**R-2829A SAFETEA-LE Section 6002 Interagency Meeting
(Concurrence Point 4B)**

The 30% Hydraulic Review was held in order to reach compliance on SAFETEA-LE Section 6002 (equivalent to concurrence point 4B and further know in the minutes as 4B) for R-2829A Complete 540 in Wake County. The following items were discussed and conclusions reached:

PROJECT REFERENCE NO. R-2829A	SHEET NO. 12
R/W SHEET NO. ROADWAY DESIGN ENGINEER	HYDRAULICS ENGINEER
INCOMPLETE PLANS DO NOT USE FOR R/W ACQUISITION

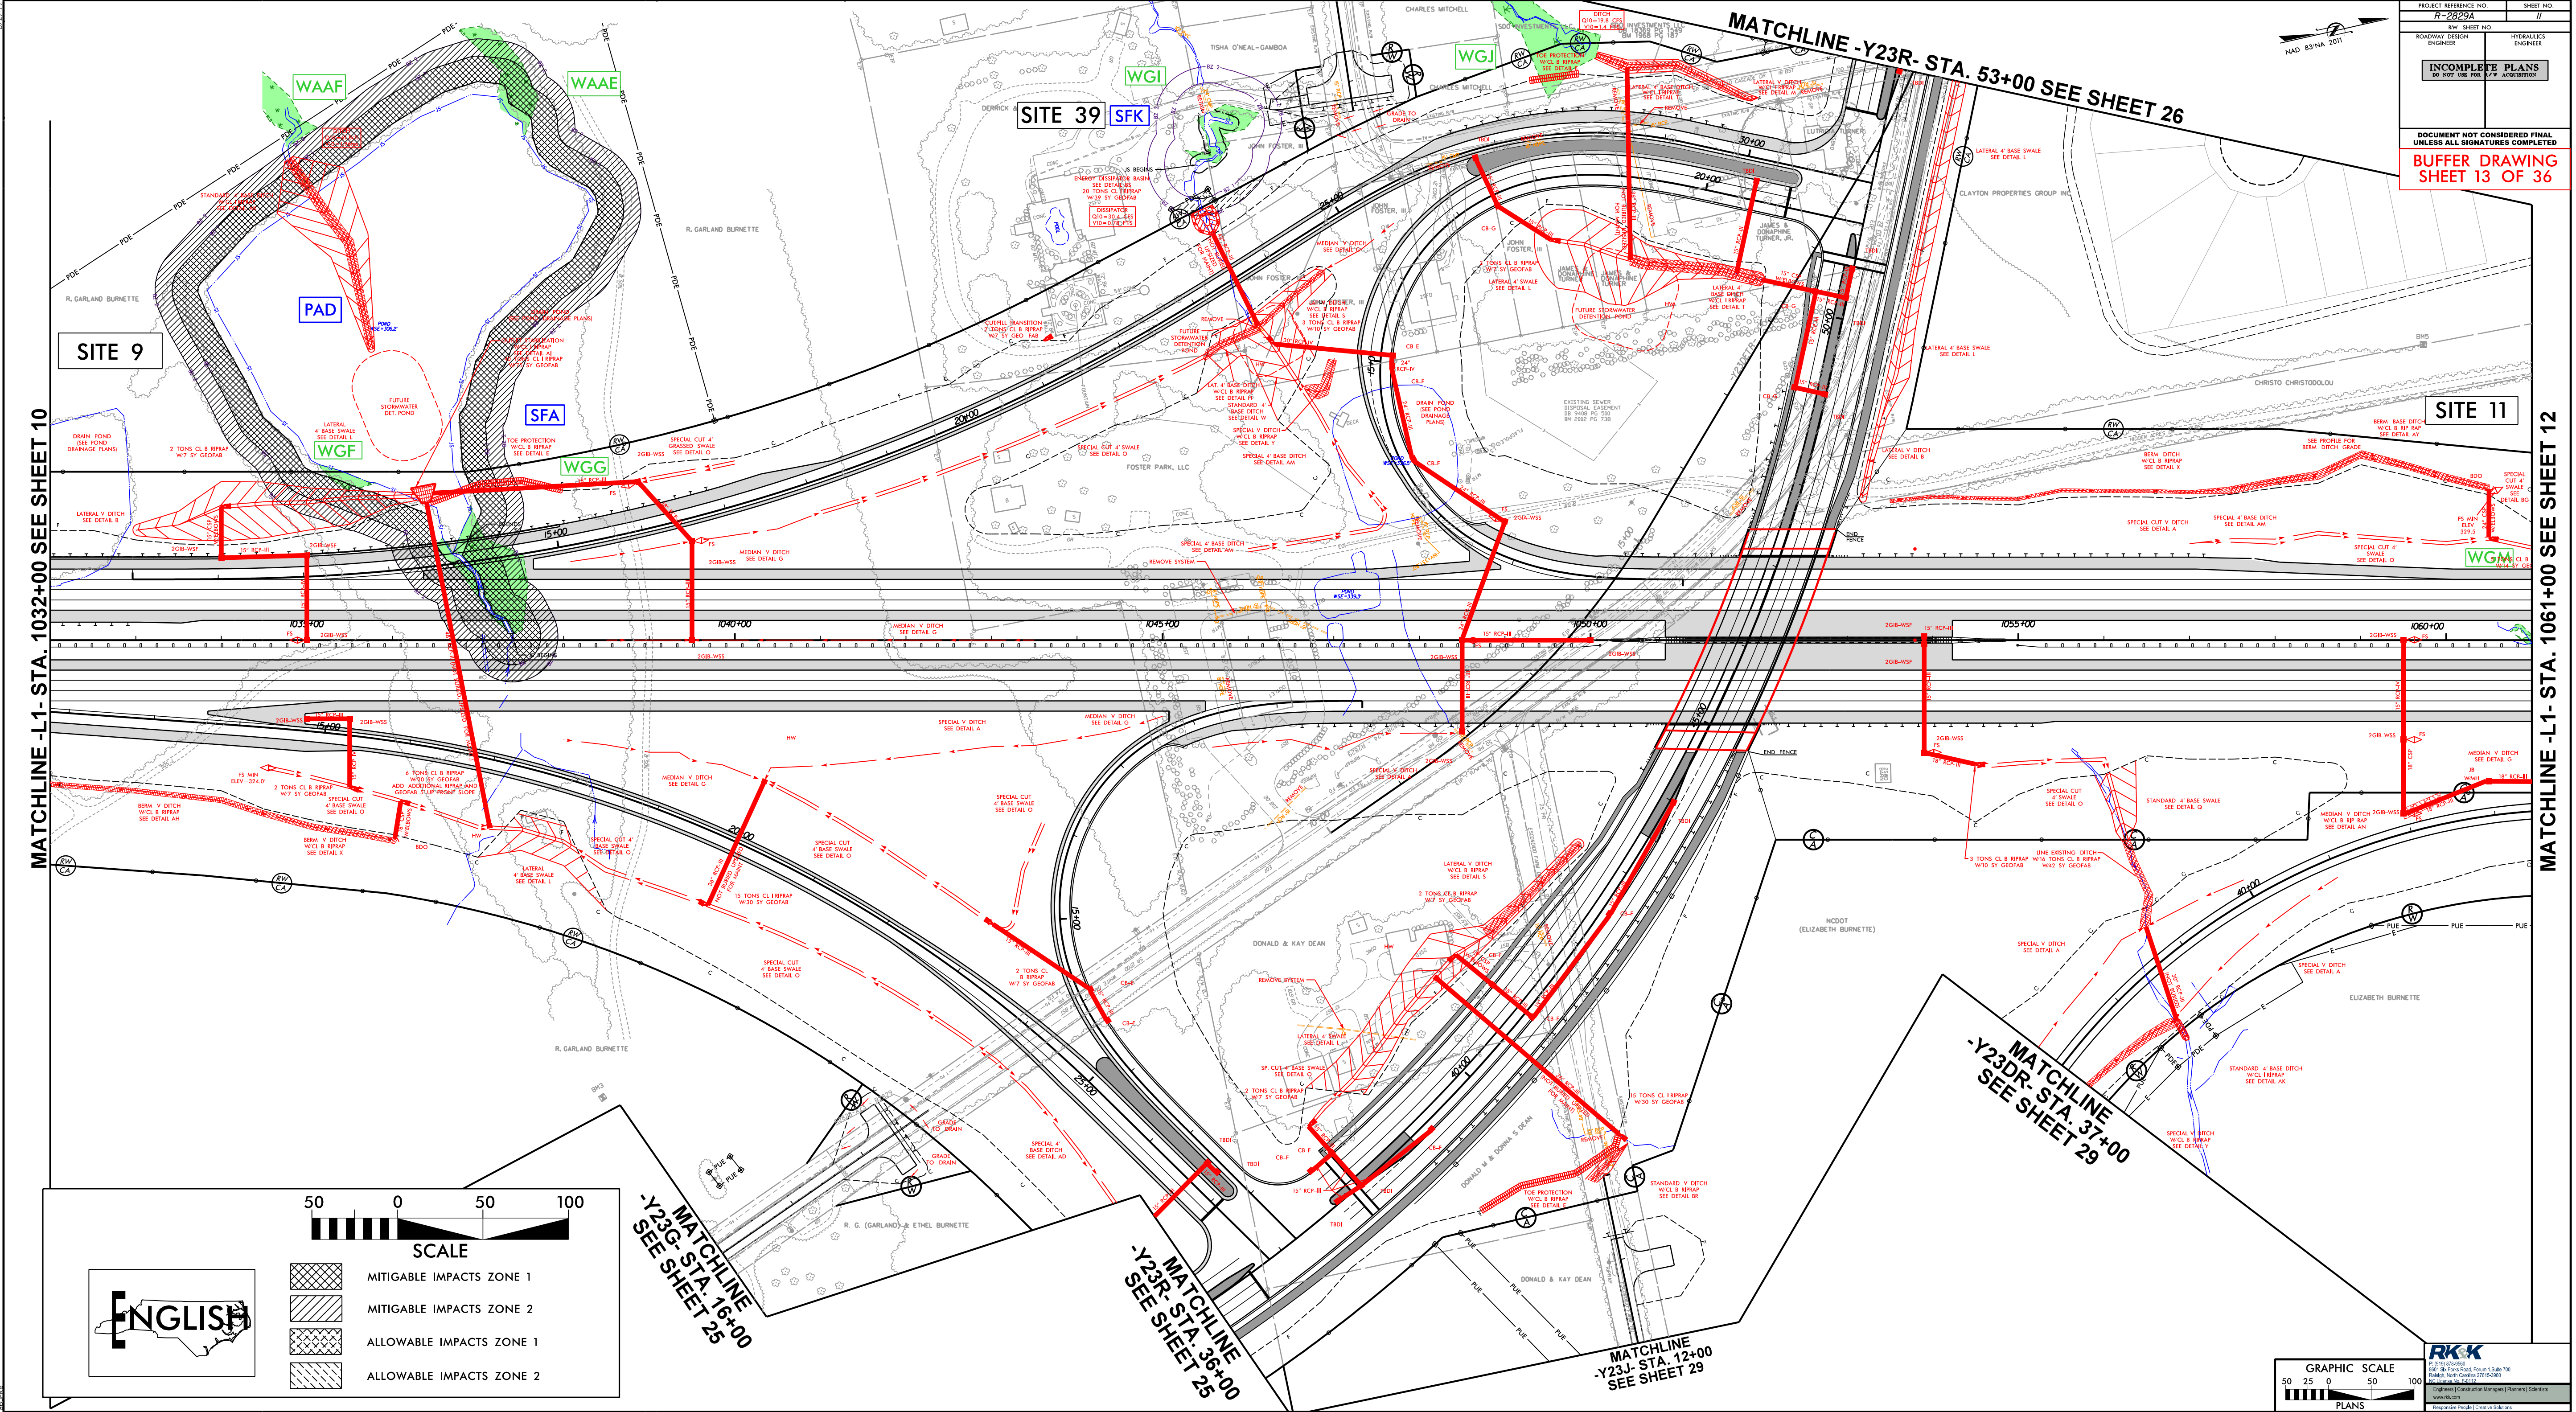
- Pond PAD: Permit site #9, will be completely drained according to the 'pond drainage plan'.
- Wetlands WAAF & WAAE: were added via a supplemental survey conducted by Kimley Horn after the initial permit and were included as part of a supplemental NRTR. These will need to be provided with a new permit # for their impacts.

- WAAE will be a total take per discussions due to this wetland being the overflow of the pond that is being drained and the wetland no longer viable. The permit # for the impacts will be part of site #9.

- WAAF discussed to be a temporary impact to remove the dam on the existing pond, however it will not be a total take since water will still be received.

- Stream SFA: Permit site #9, 48" RCP (Not buried) due to no jurisdictional call at upstream end. Stream SFA is a total take.
- Wetland WGF: Permit site #9, total take; borders on edge of drained pond PAD (was not part of the original permit package impacts).

- Wetland WGG: Permit site #9, total take under roadway fill.
- Mr. Cook noted that in the original permit, there is an open area with no jurisdictional functionality between pond PAD and wetland WGG. Also, originally stream SFA tied into the pond. A new file provided by NCTA stops the stream short of the pond. Mr. Cook asked if the pond should continue up to wetland WGG. It was agreed that it should.

- Mr. Cook noted that the DB team has preliminarily shown a stormwater detention pond inside the limits of the drainage pond PAD due to a velocity concern of the post Q leaving the construction site. The proposed pond would likely be built with a berm across the middle of the existing pond PAD to limit excavation needs and maintain the existing footprint.

- Ms. Duprey had concerns about constructing a new pond within the limits of an existing drained pond due to EPA requirements.
 - Mr. Ridings & Mr. Matthews noted that the EPA standard in question is at locations where a jurisdictional resource is used as an inline system because it potentially takes everything downstream out of jurisdiction. This site is completely removing pond PAD's jurisdictionally with no jurisdictional features upstream; however, wetland WAFF and other off-site jurisdictional features may remain downstream. Mr. Matthews stated that he would check into this and report back during the 4C meeting.

BUFFER DRAWING
SHEET 14 OF 36

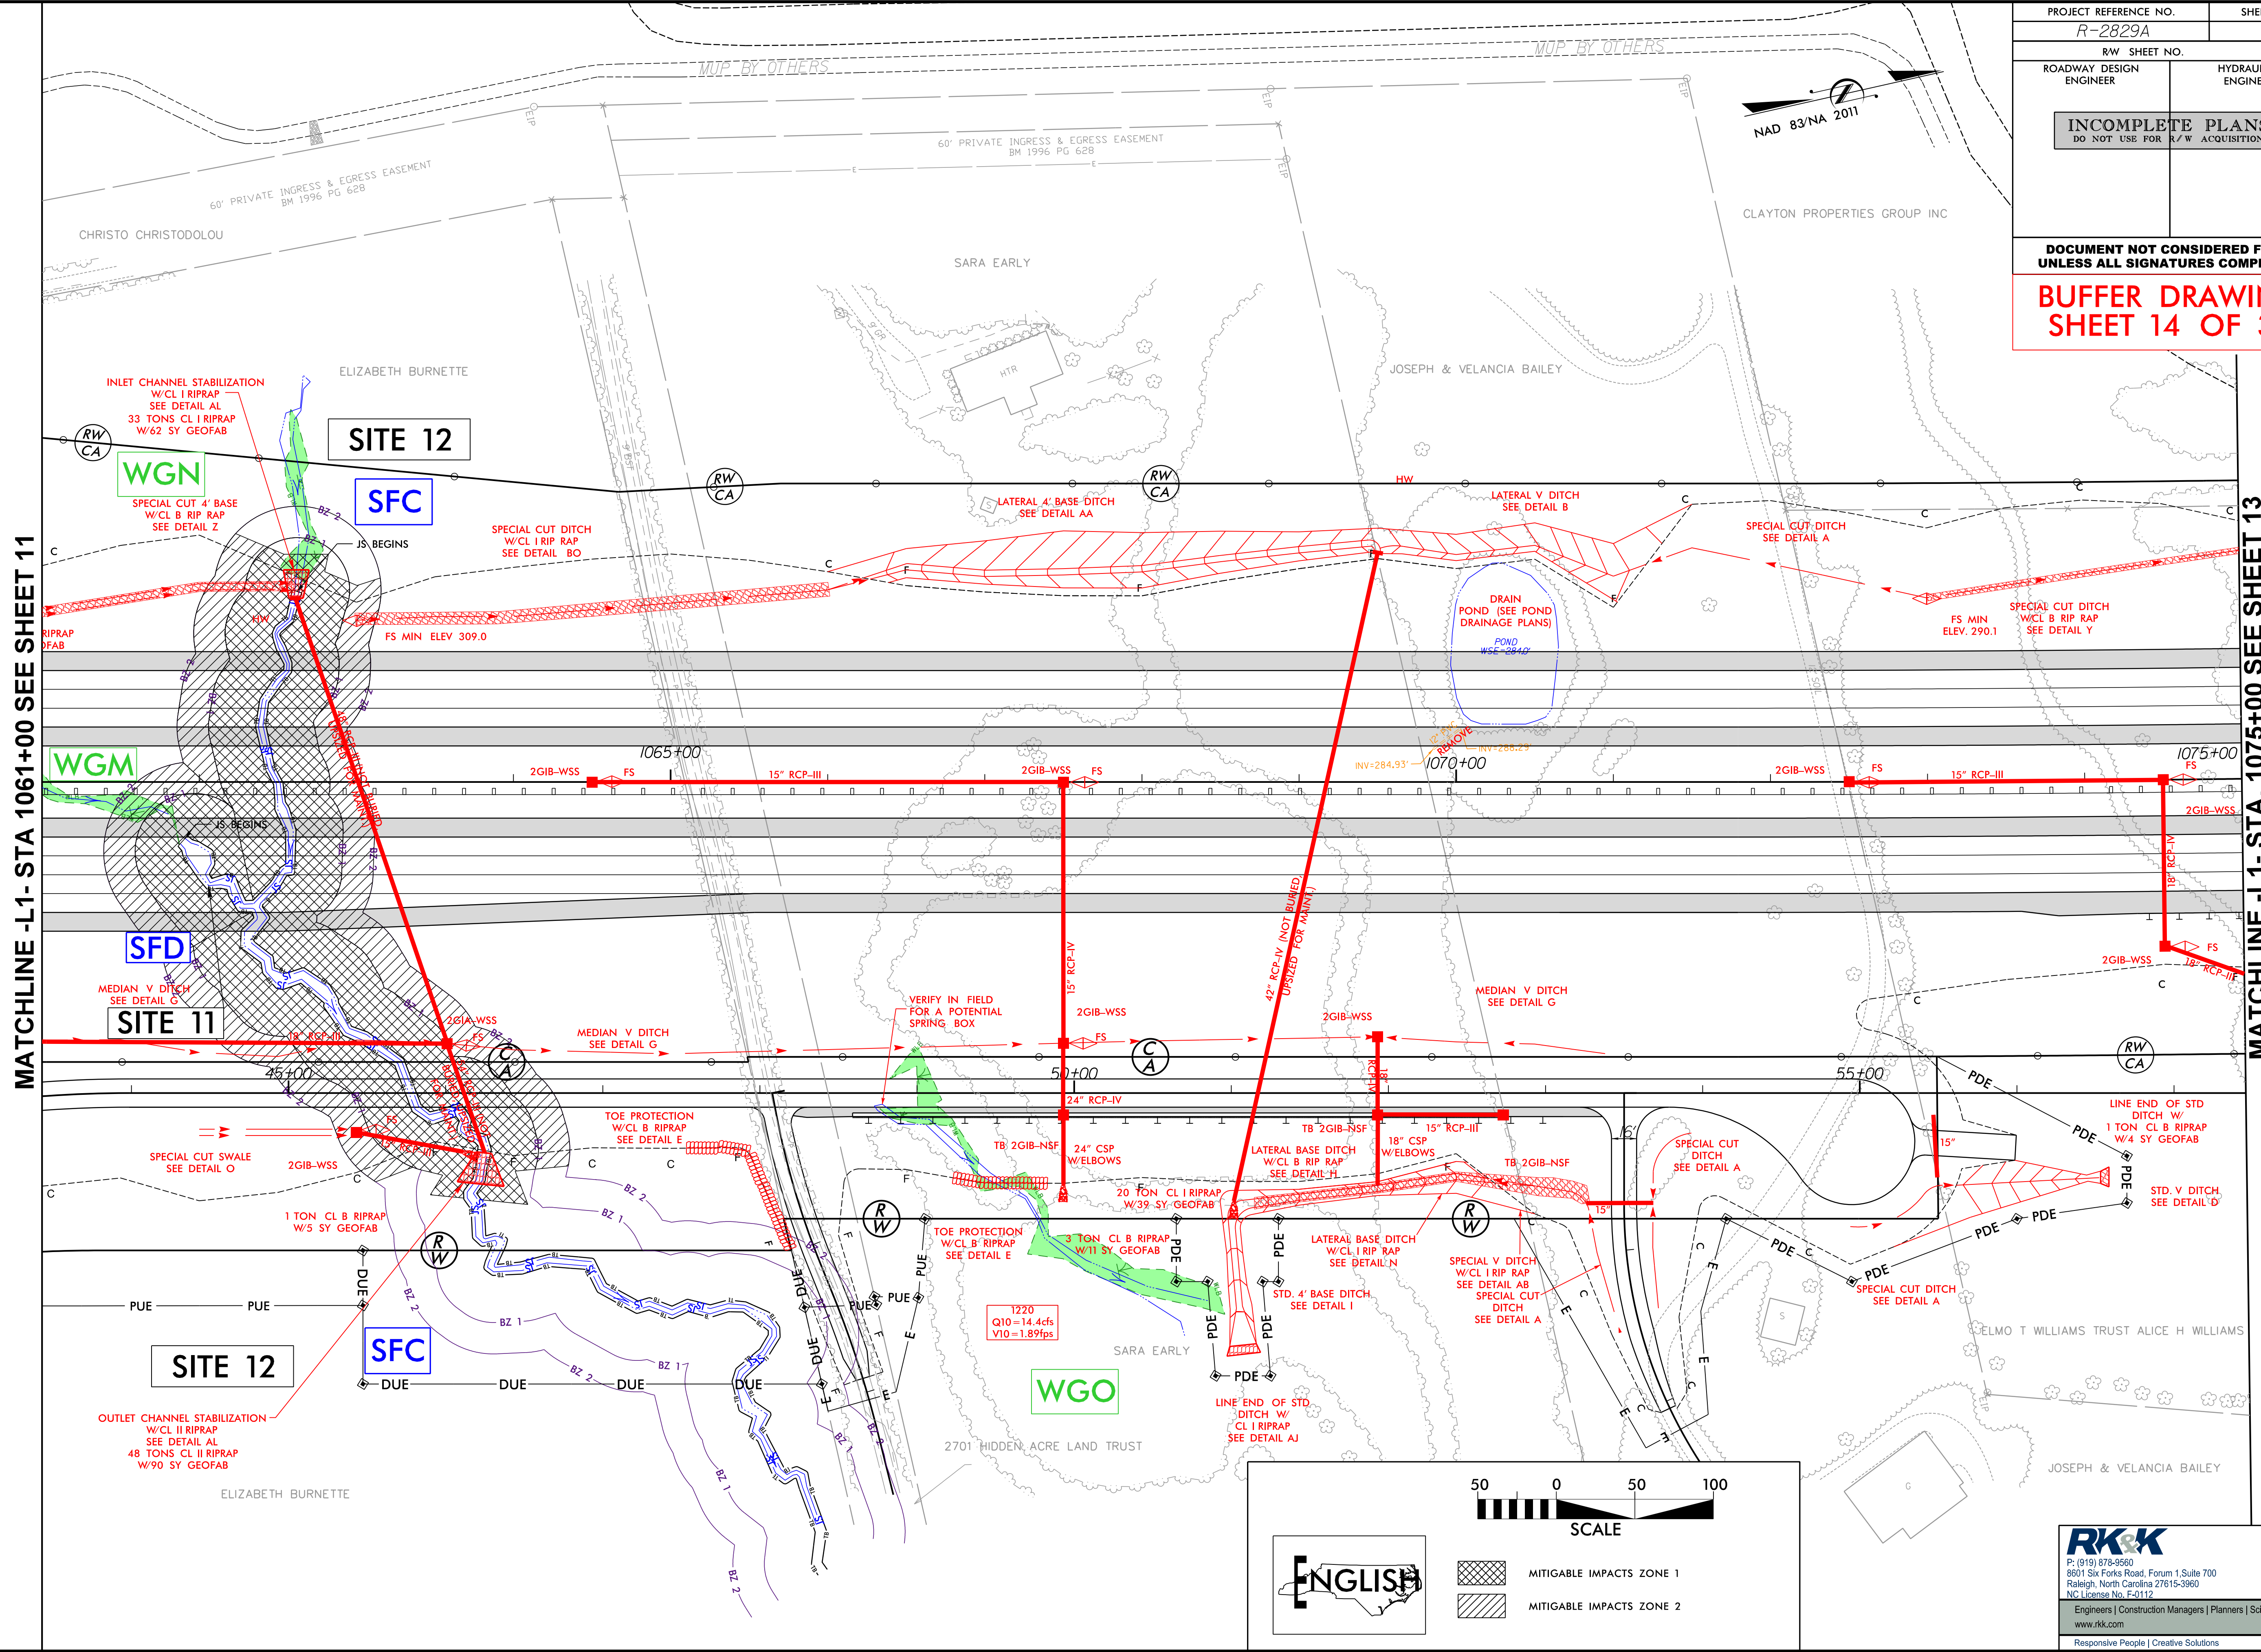
- Wetland WGM: see notes on plan sheet 11.
- Stream SFC: permit site #13, 48" RCP (Not Buried), as the jurisdictional stream begins just below the headwall of the pipe – "JS Begins" label will be added at this location.
 - Due to wetland on inlet and stream on outlet end; inlet end of pipe will have class I riprap countersunk riprap pad and outlet end will keep class II as shown.
- Wetland WGN: permit site #13, 48" RCP (Not Buried). Impact due to the countersunk riprap pad. This wetland will not be a total take.

- Stream SFD: permit site #12, total take
- Wetland WGO: Permit site #14, impact due to roadway fill and toe protection.
 - Ms. Fleming noted that a spring box may be necessary around -Y23DR- 49+00 to continue feeding the wetland WGO. Mr. Bivens noted that if they were to encounter a spring during construction, they would have to install a spring box regardless to avoid a failure of the roadbed. Mr. Cook stated that a potential spring box note will be added to the plans in this area.
 - Discussion was held concerning the viability of the wetland given the overland flow changing in the area due to the roadway facility. Mr. Cook pointed out the majority of the -L- and -Y23DR- drainage was designed to continue to feed the wetland.
